Subject: 2024/93420 at location adj, 330a, Leymoor Road, Golcar, Huddersfield, HD7 4QL

Please see my ecological comments below:

Biodiversity net gain

Proposed Block Plan

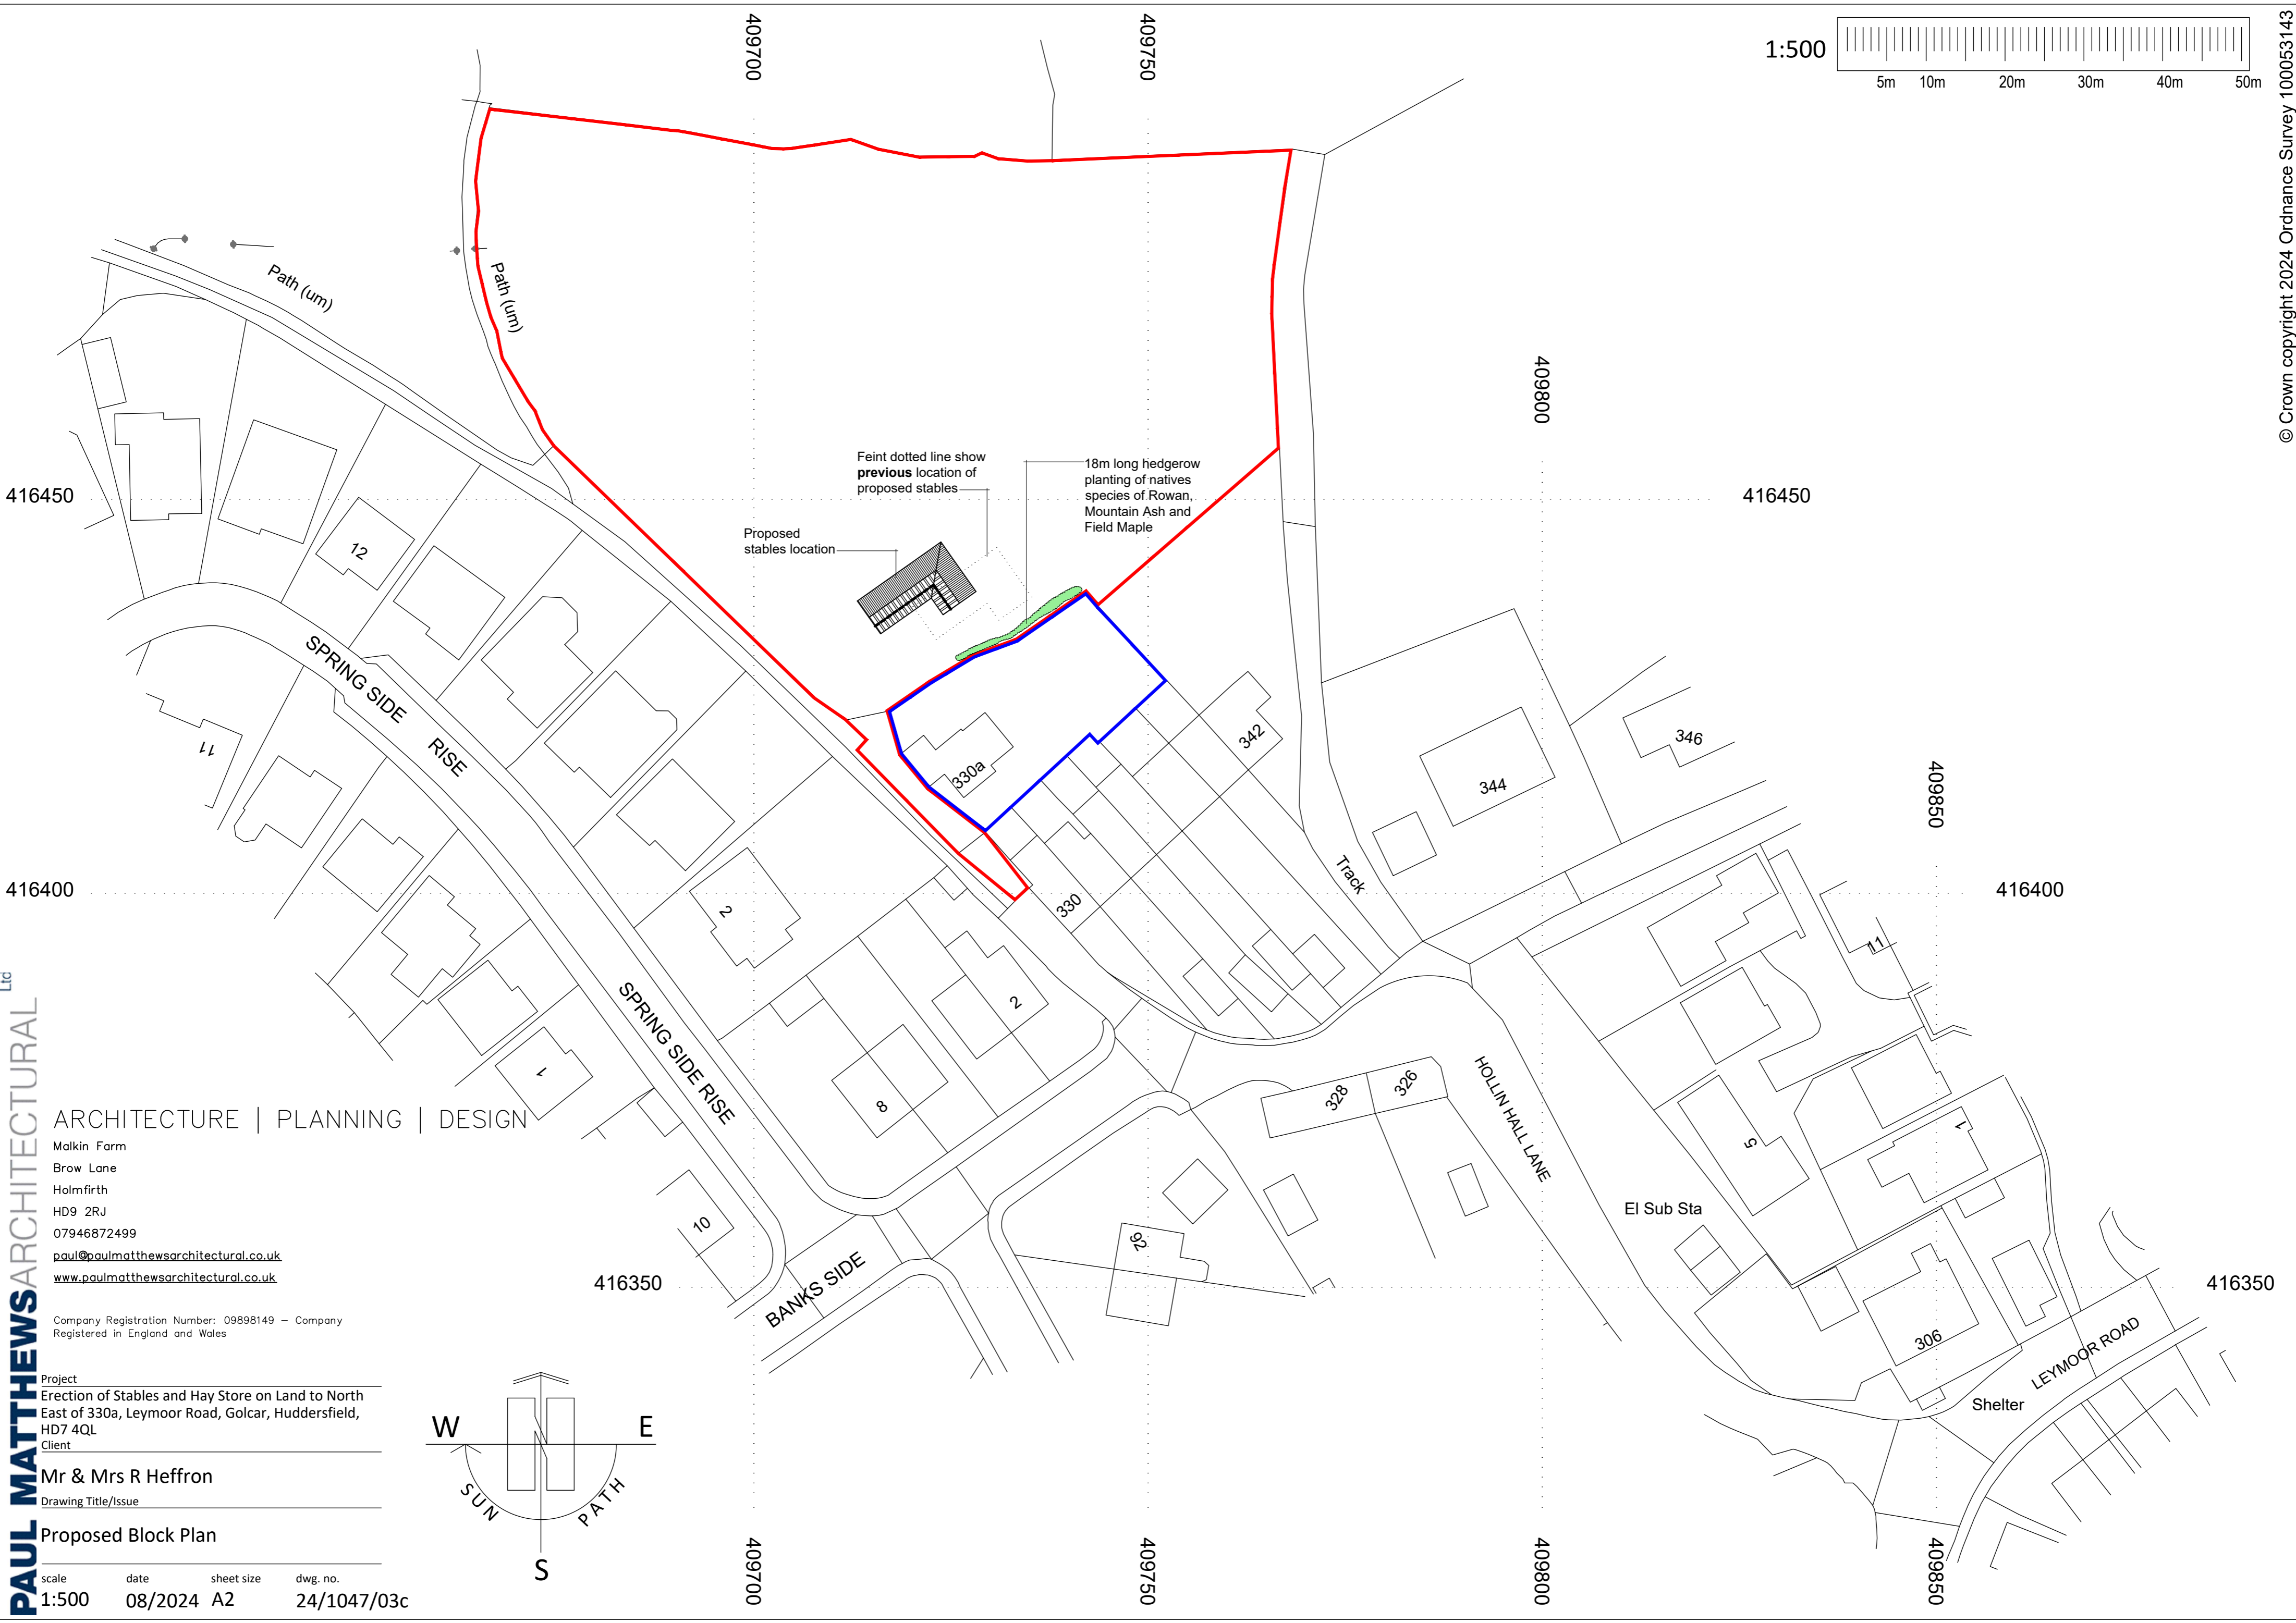
The BNG reports that a net loss will occur on the site after works. As a result, we cannot accept this.

A gain plan for this application must present a viable proposal for achieving net gain. As this may involve more on-site land than currently allocated within the red line, it is recommended that the proposal is reconsidered prior to determination of the application. This is to ensure the development delivers a biodiversity net gain on site in accordance with Schedule 7A of the Town and Country Planning Act 1990.
